Arun District Council
Arun Civic Centre
Maltravers Road
Littlehampton
West Sussex BN17 5LF
Planning & Building Control General Enquiries
Tel: (01903) 737756 Fax: (01903) 730442
Dx: 57406 Littlehampton
Minicom: 01903 732765
e-mail: planning@arun.gov.uk
website: www.arun.gov.uk/planning

Application No: Y/123/21/PL
Site Address: Land to the south of Ford Lane and East of North End Road Yapton BN18 0DS
Description of works: Variation of condition imposed under Y/82/20/RES relating to condition 1 - plans condition.

Thank you for your internet representation made on 11th October 2021 which has been recorded as an objection with the comments as follows:

ENCLOSURES PLAN

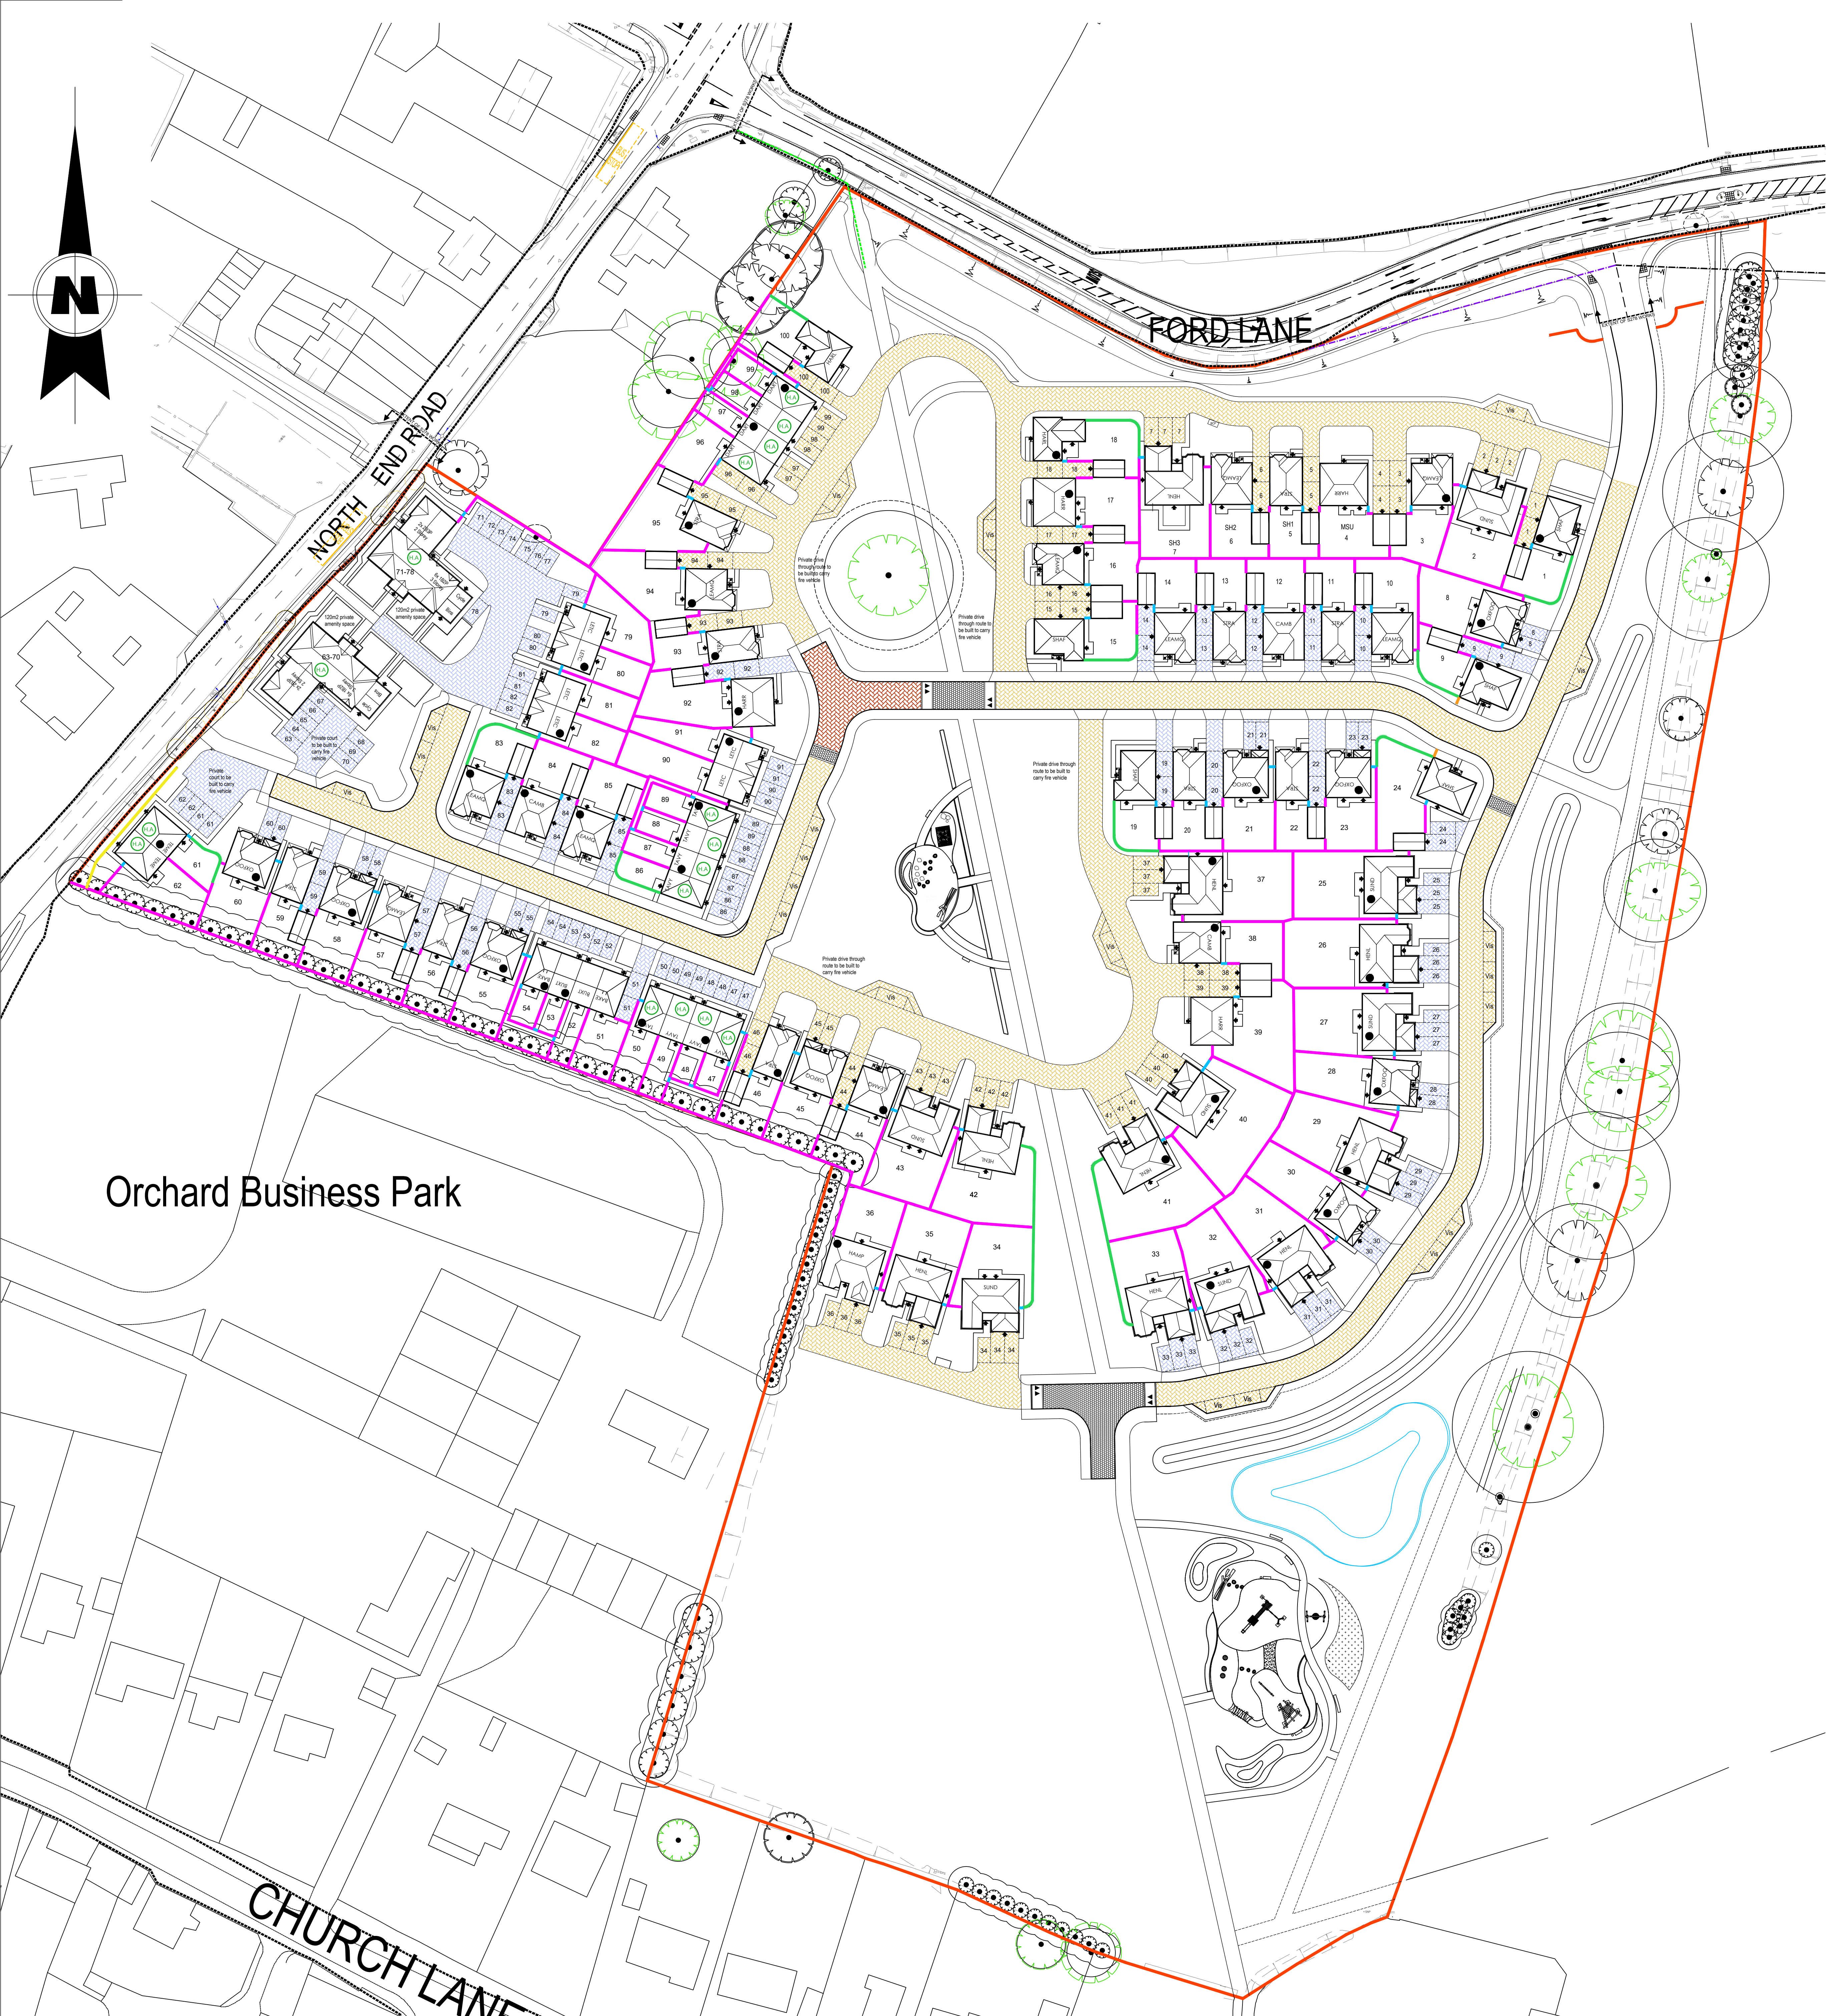
YPC also note that the landscaped bund has not been continued along the whole south boundary fronting the access road (land opposite plots 34/35/36). It should be recognised that YPC has over many years suffered from unauthorised vehicles accessing its open space to the detriment of the Parish and its residents. YPC would therefore recommend that this bund is continued to ensure a soft landscaped but effective green barrier between the road and open space. This will provide both a safe barrier to prevent children running onto the road as well as prevent unauthorised vehicular access. In line with this YPC would request that a condition is placed to ensure that the turning head has a strong a secure locking gate to prevent unauthorised vehicular access into the open park land.

**Title:**  
PLANNING LAYOUT

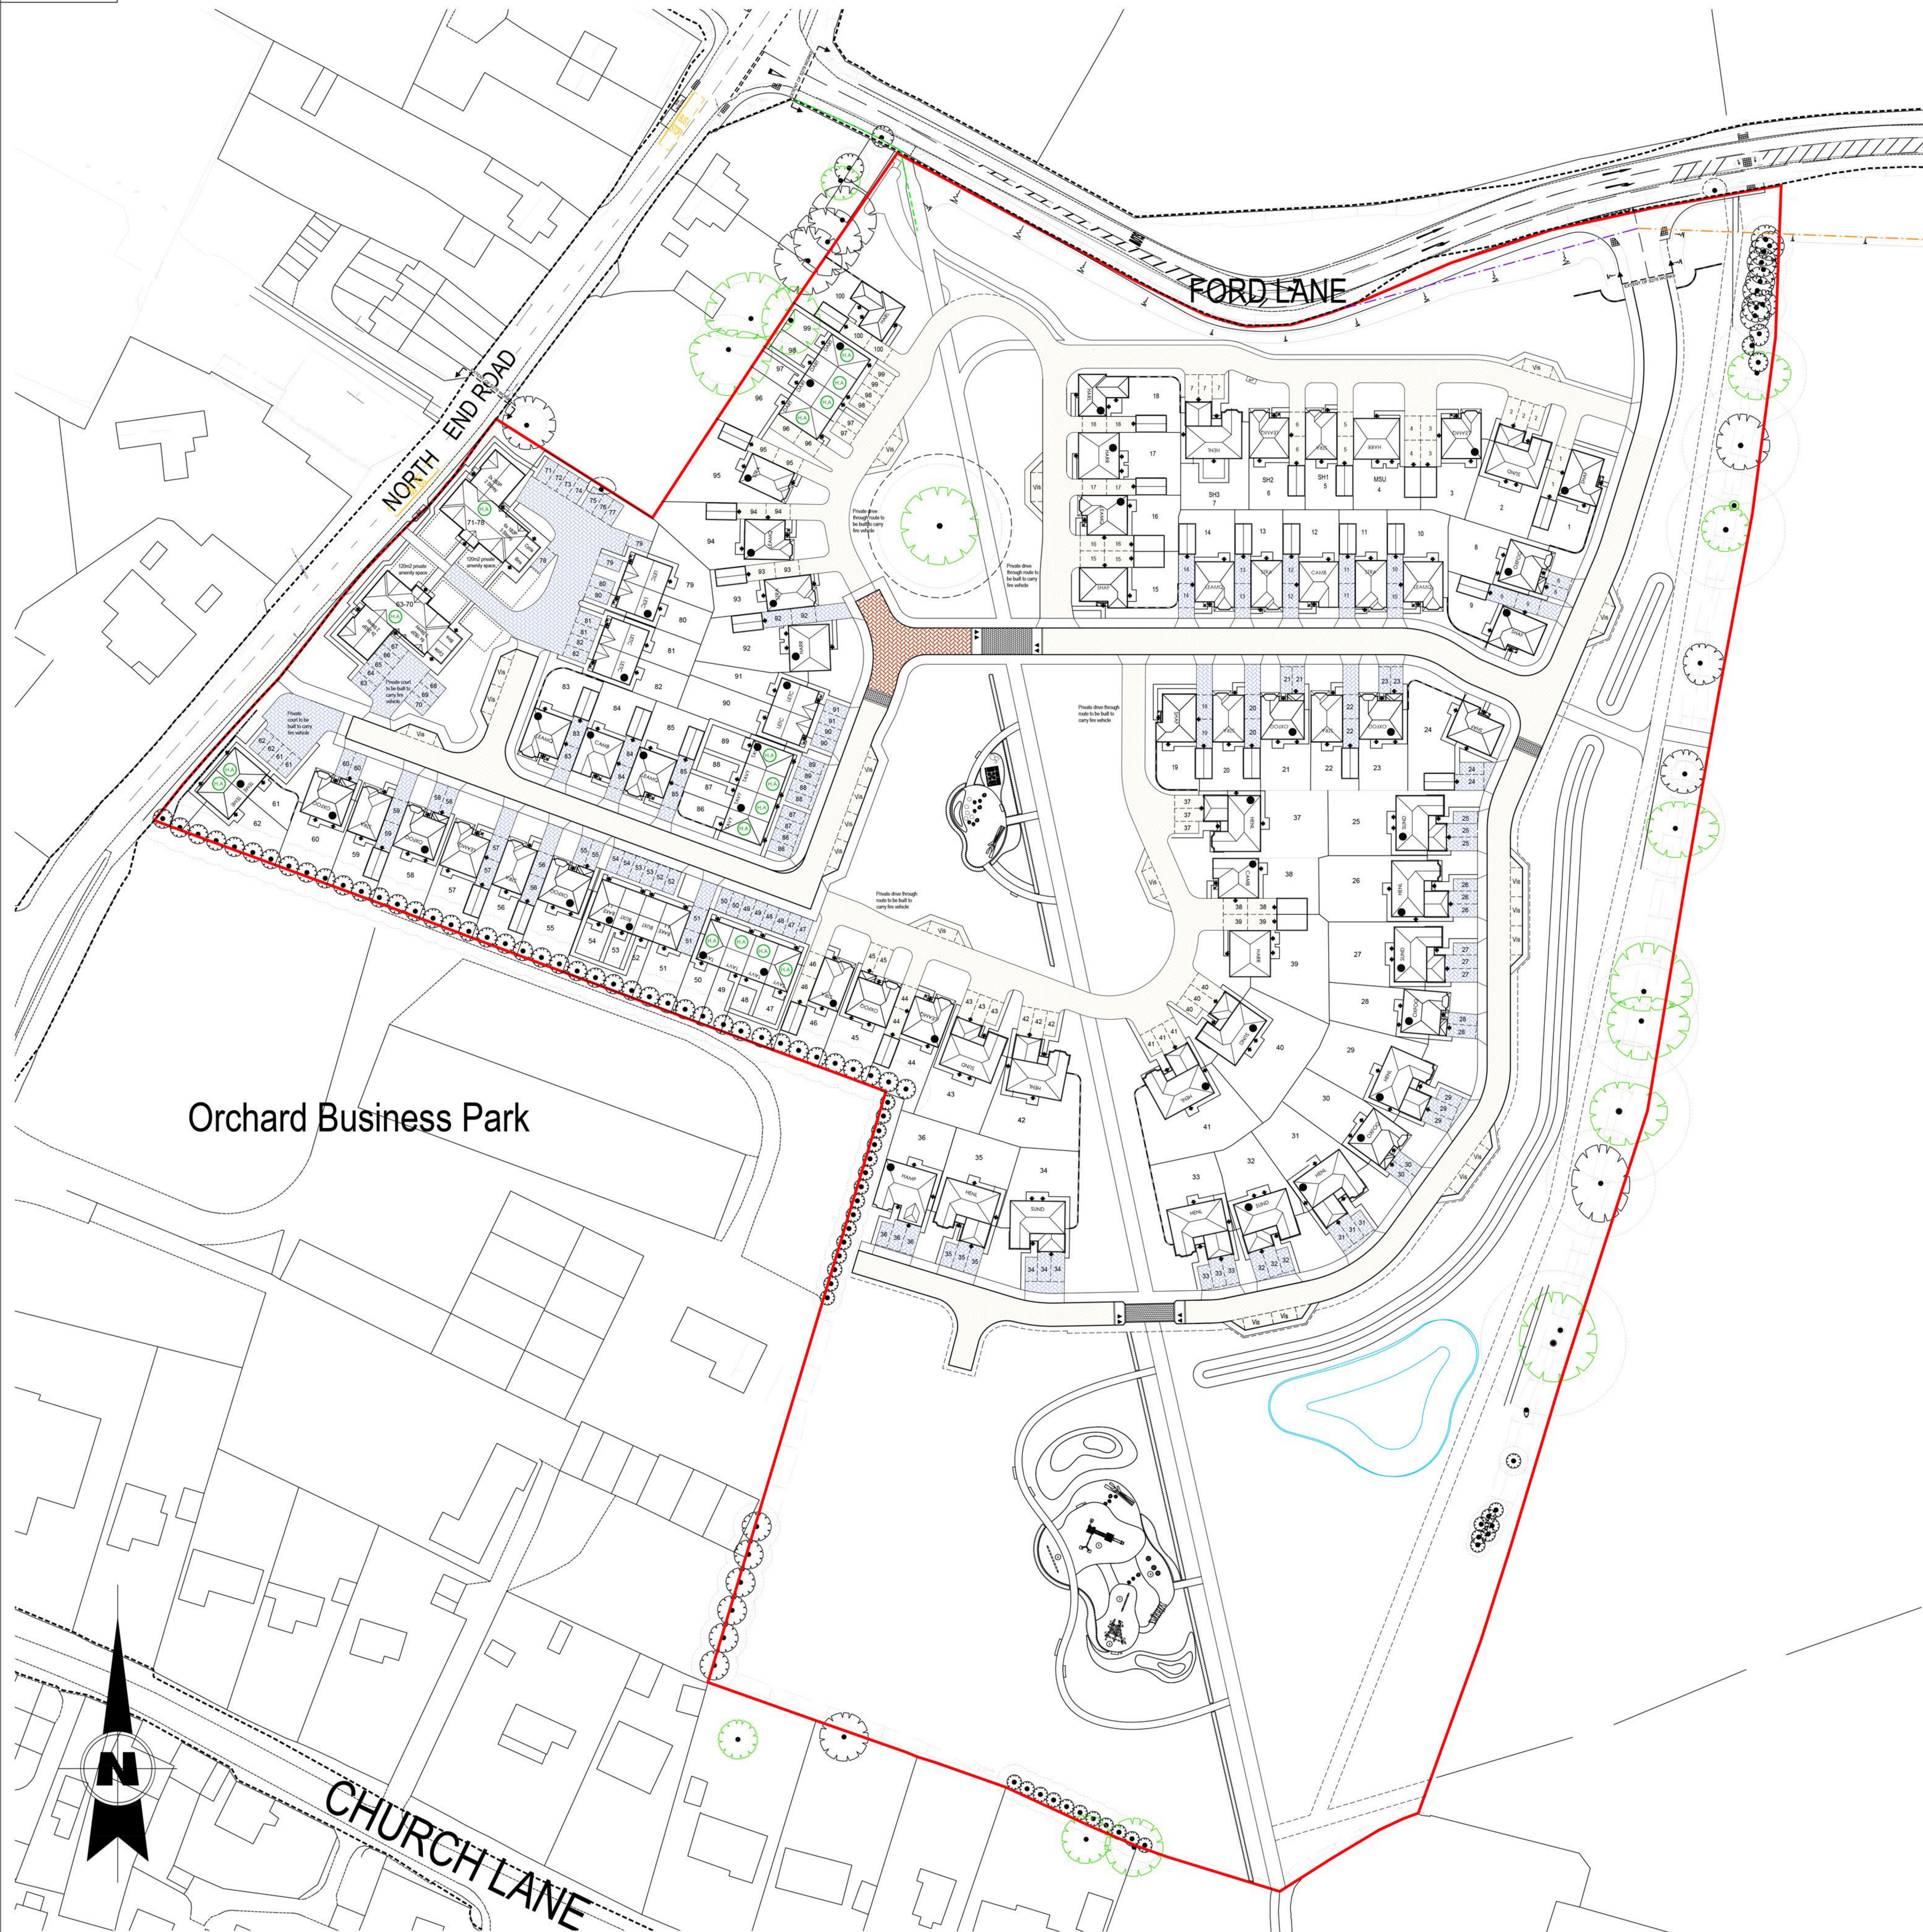
YPC have considered the above application and would comment that whilst the amendments are minor, they do present an opportunity to distance the southernmost play area away from the proposed infiltration pond. YPC has consistently raised concerns with the proximity of the infiltration pond to the southern LEAP and potential risk associated with younger children and water. YPC would therefore request that the relocation of the LEAP from the south-eastern plot of open space to the south-western plot be considered. This would distance the LEAP from the infiltration pond removing a potential Health and Safety risk.
